Please ask for: Kathryn Welch
Email: kathryn.welch@arun.gov.uk
Telephone: 01903 737789
Our Ref: BE/19/21/T
Your Ref:
Date: 12th February 2021

Application for Works to Trees(s) subject to a Tree Preservation Order(TPO)

Development: Various Works to various trees within retail park.
Location: Arun Retail Park Shripney Road Bognor Regis PO22 9NF

Q161-01 Tree Survey Plan

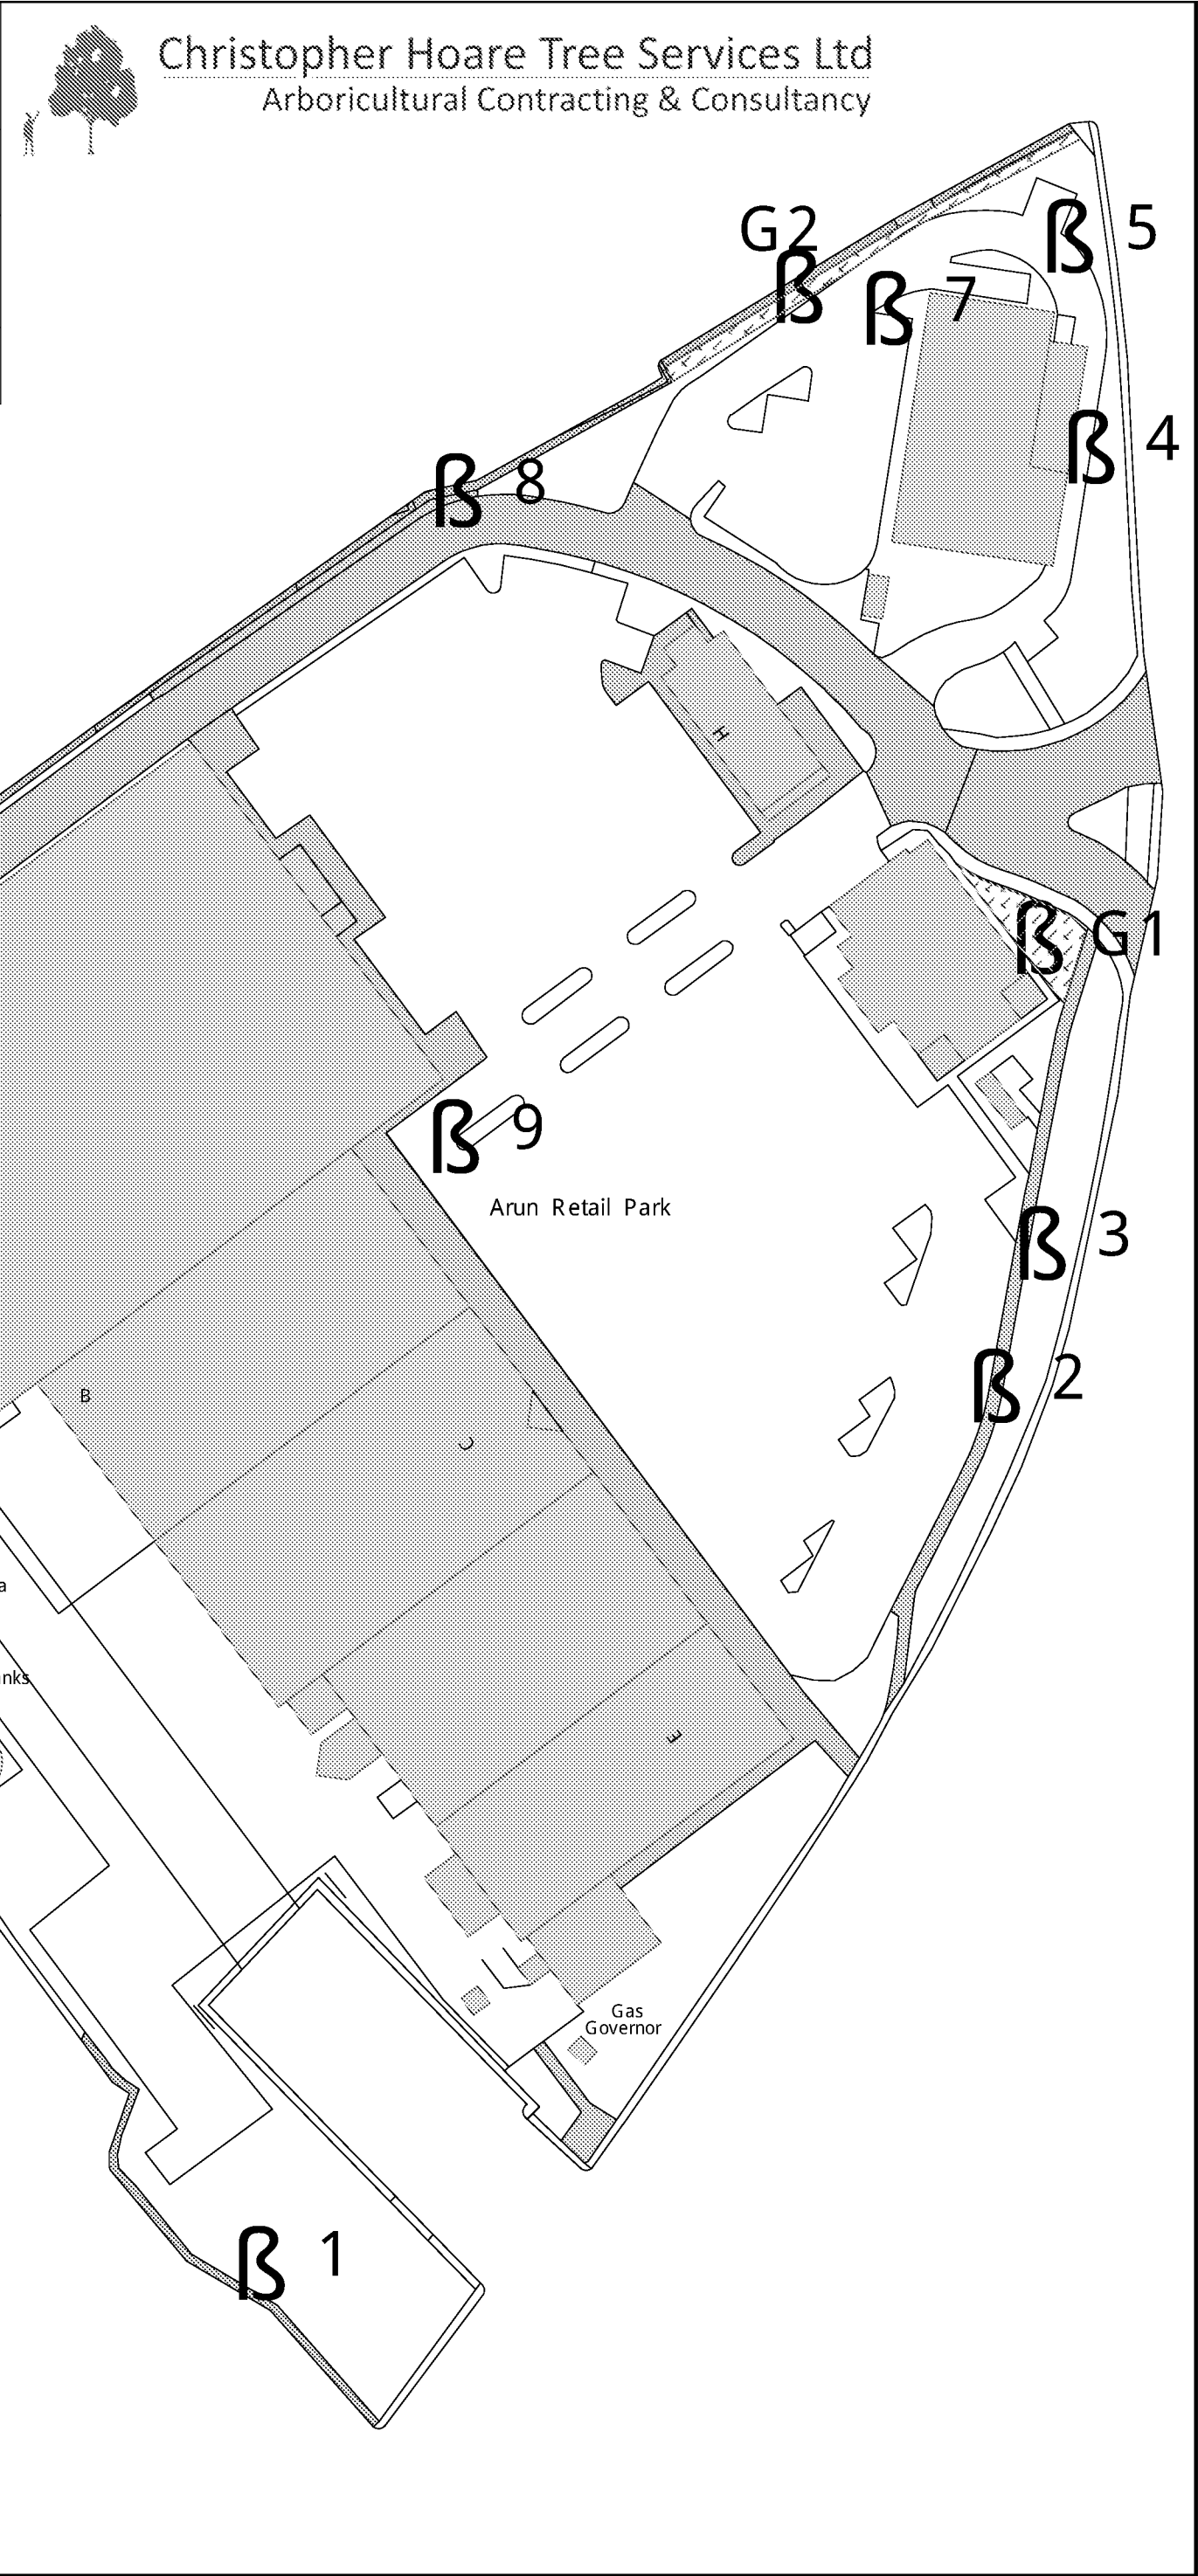
Please provide details of replacement tree in lieu of tree 3.

Please provide proposed spread measurements (m) for trees/groups;

-G1 & G2

-1 & 7

Where the works are not radial then please also provide details as to which direction (NSEW) works will be undertaken.
